**RE: PARK PLACE MOBILE HOME ADDITION (L20-D50). GRADING AND
DRAINAGE PLAN FOR BUILDING AND SO #19 PERMIT APPROVALS.
ENGINEER'S STAMP DATED MARCH 24, 1998.**

**RE: PARK PLACE MOBILE HOME ADDITION (L20-D50). GRADING AND
DRAINAGE PLAN FOR BUILDING PERMIT APPROVAL. ENGINEER'S STAMP
DATED MARCH 12, 1998.**

Scale: 1" = 20'	Drawn By: B.B.	Checked By: CLW	Job Number:	Date: MARCH 1998
Drainage and Grading Plan				C-1 Sheet 1 of 1

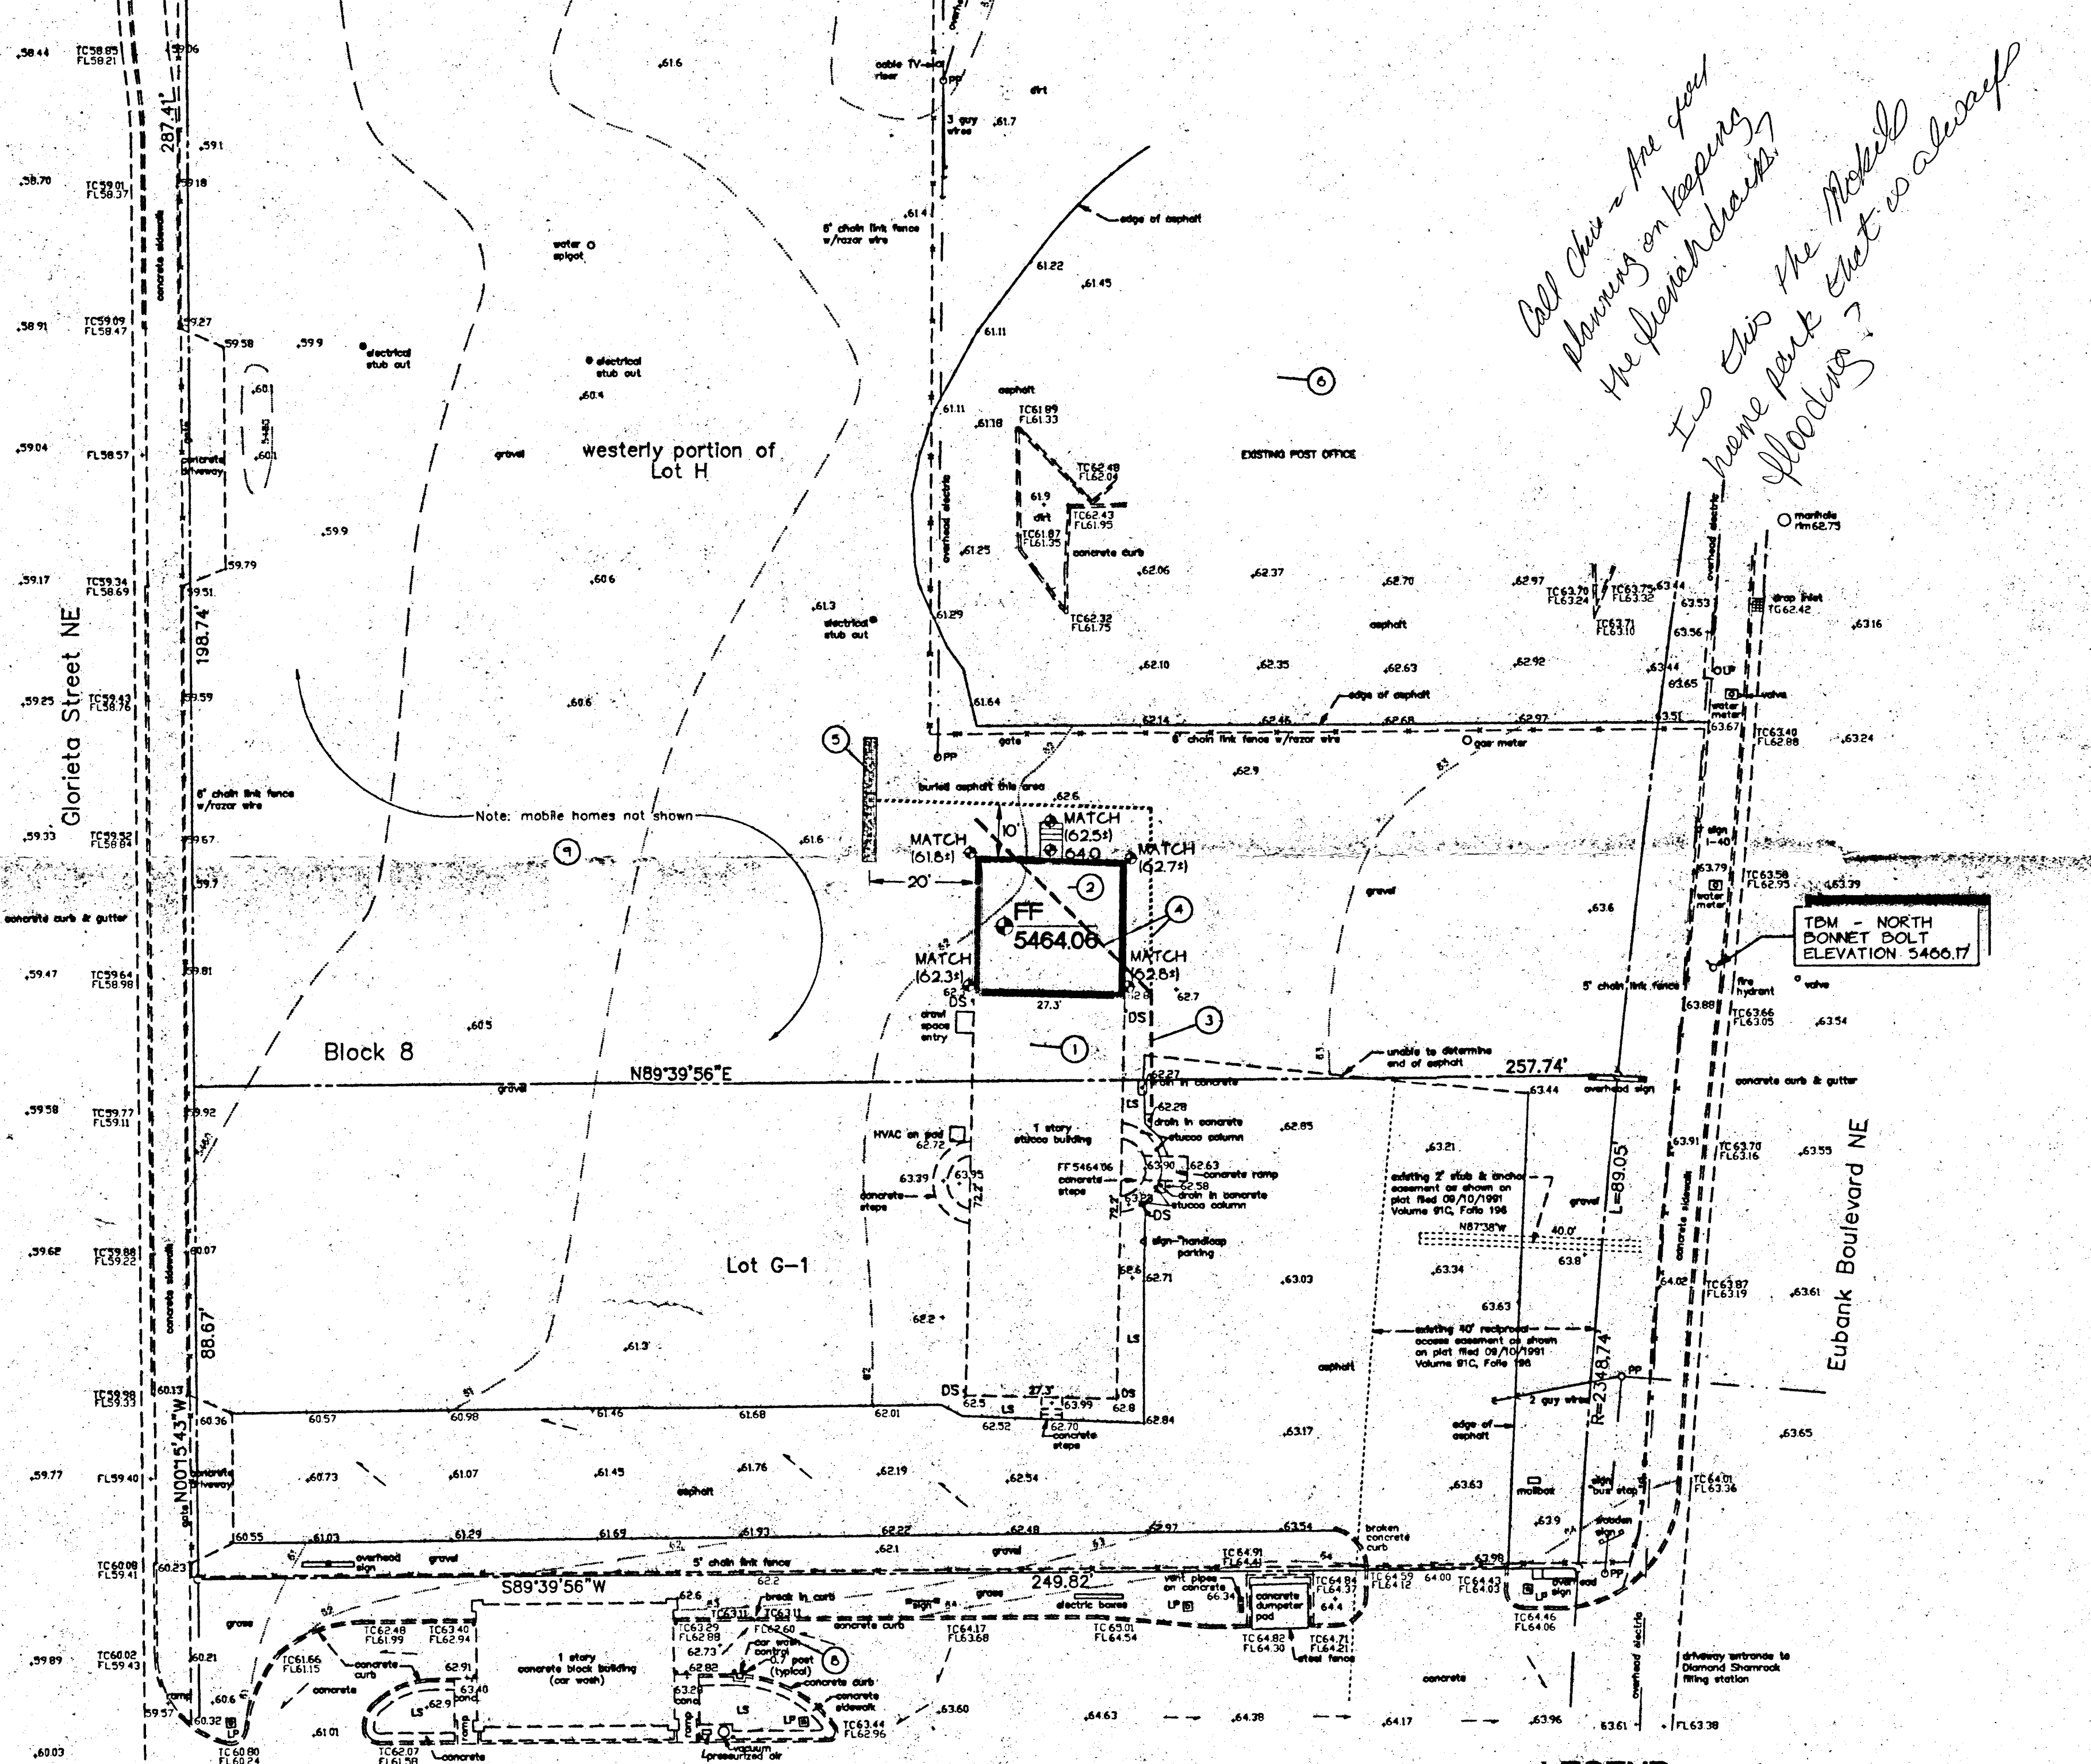
French drains are not allowed in the City of Albuquerque. Please take your flow to the street.

In general ~ Flow coming
off this site is not
a problem - it is not
clear how it gets off of
site.
